Subject: Shoreline Exemption Permit, Pump Station 20 – 8710 85TH Ave. SE.

This is a written response to the review comments provided by the Community Planning and Development Department regarding the application for the Shoreline Exemption Permit, SHL23-006, for Pump Station 20 located at 8710 85TH Ave. SE.

INSTRUMENTATION
PUMP STATION 20 - PLAN

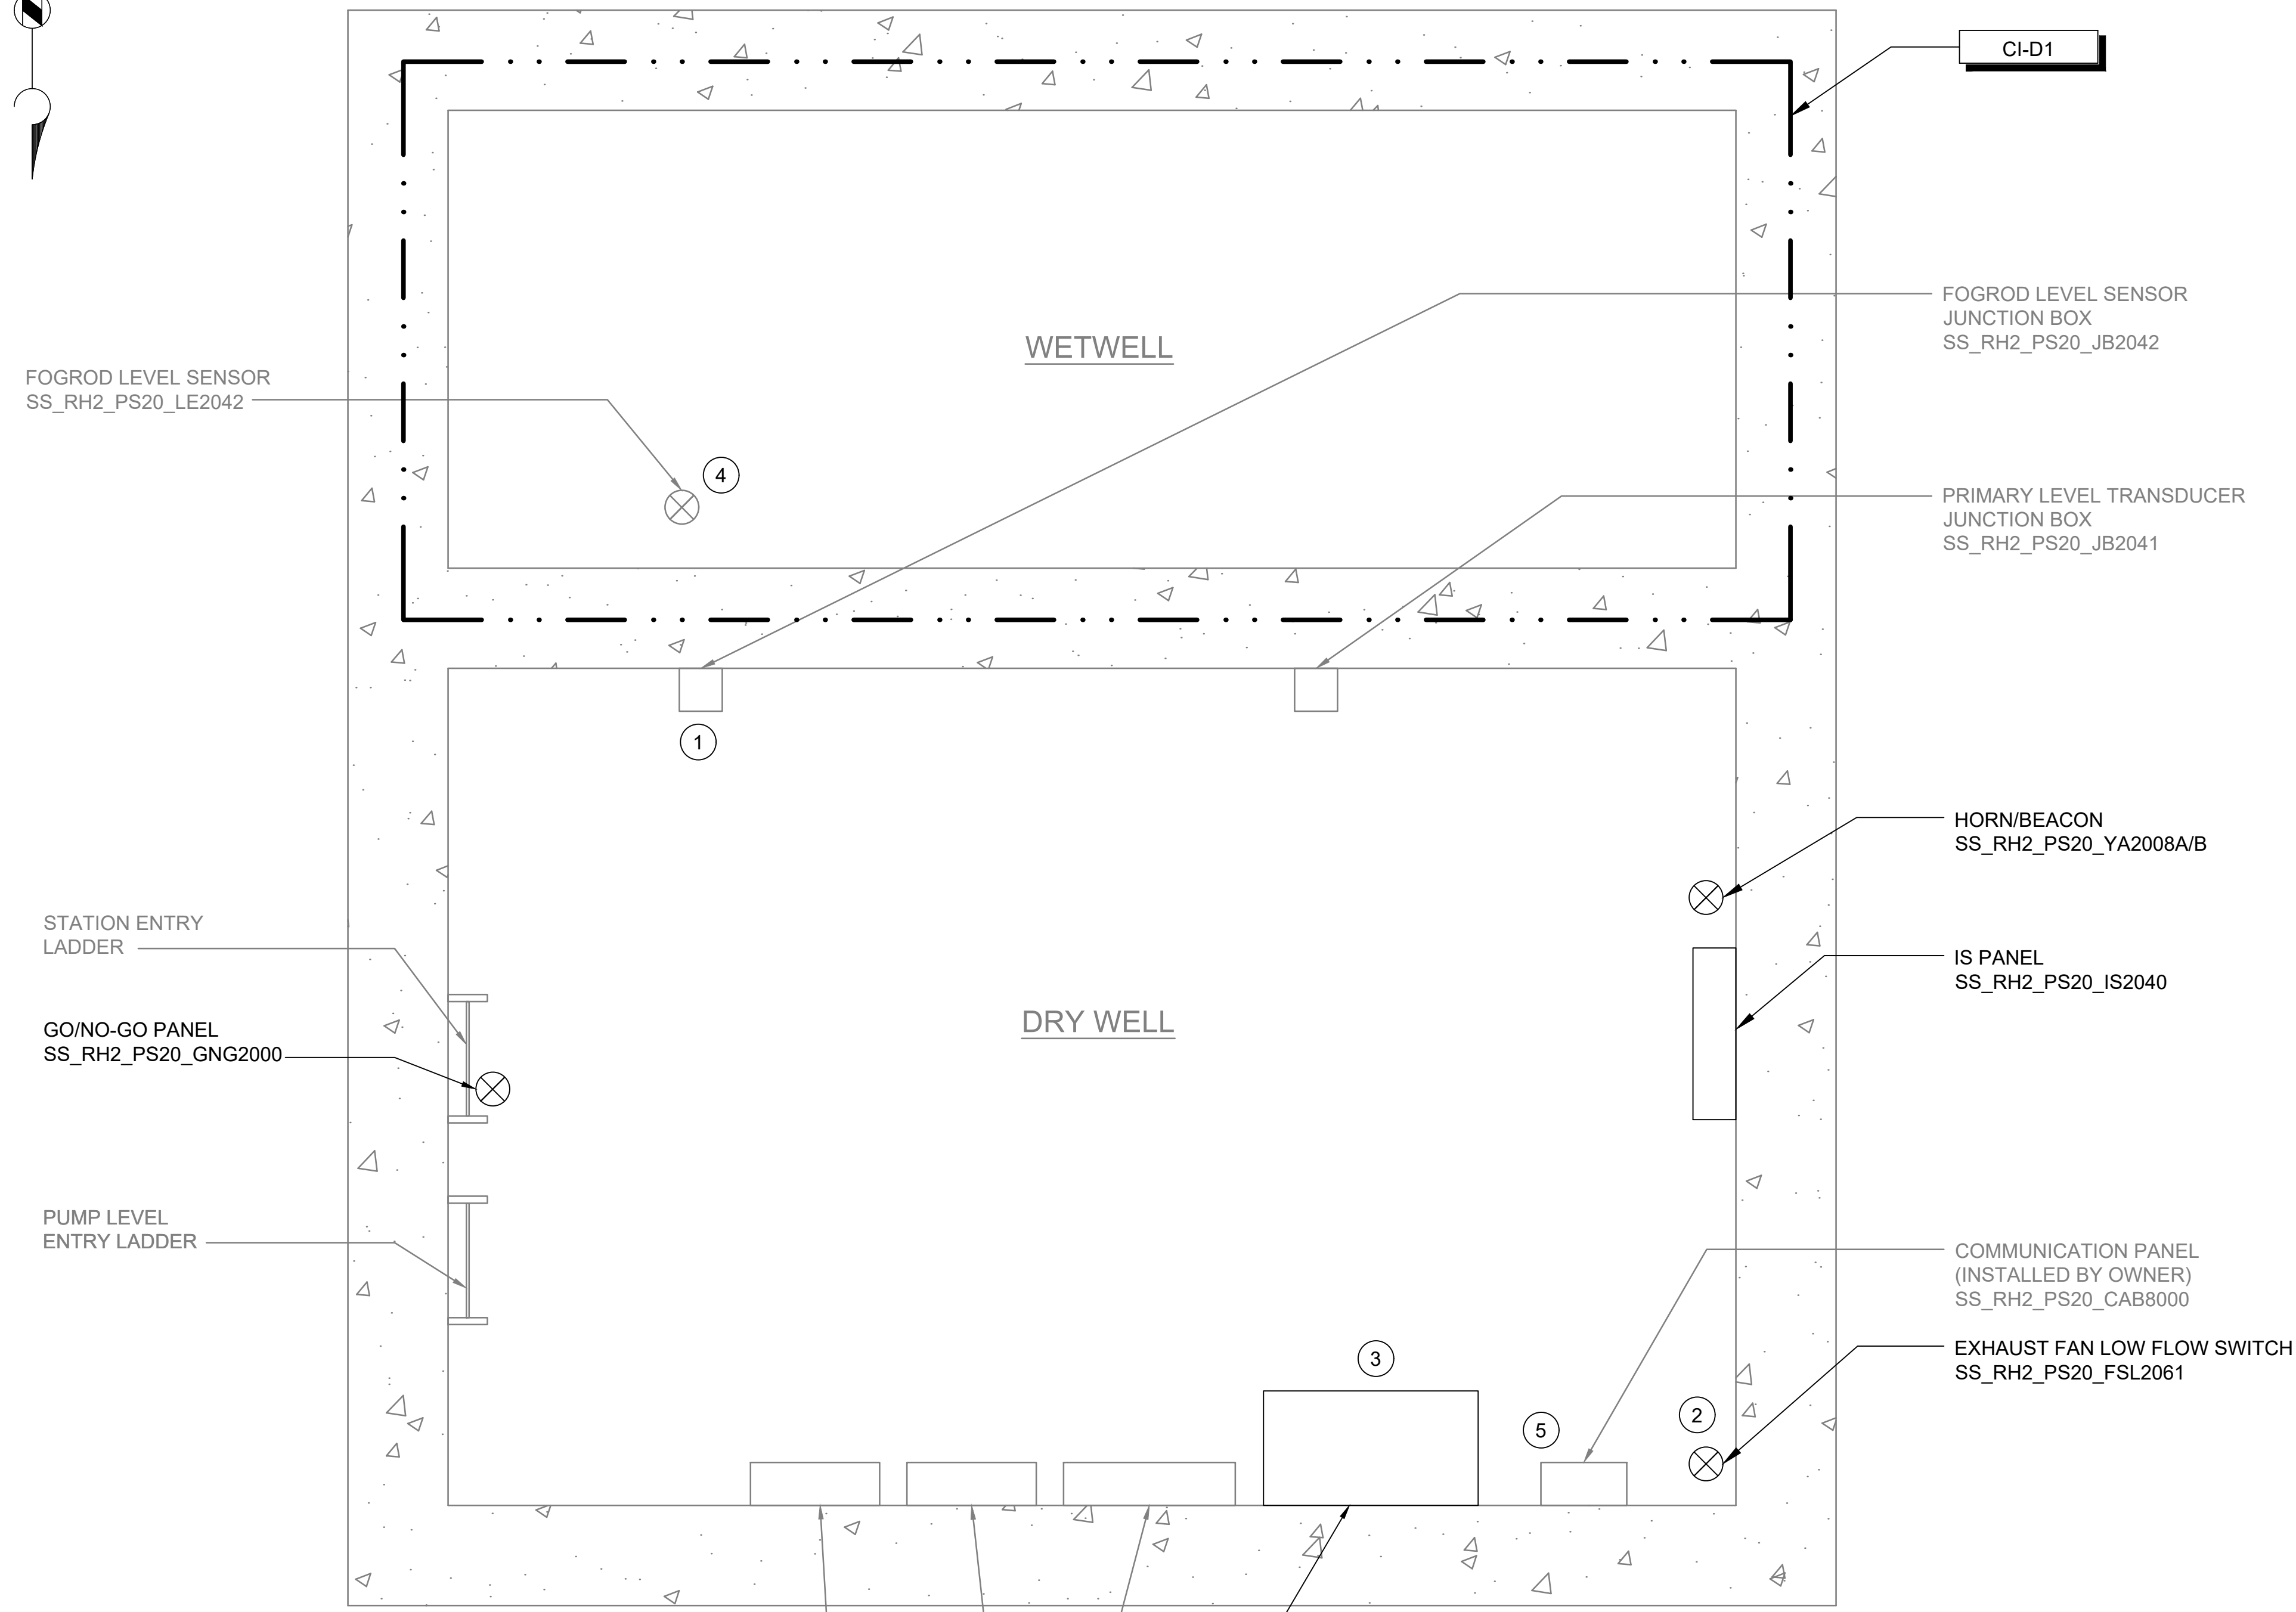
- a. Provide address of all pump stations on plans

Response: *The address for the pump station has been added to Development Plan, Instrumentation Drawing page 1. The address was also included in the aerial photo of the pump station.*
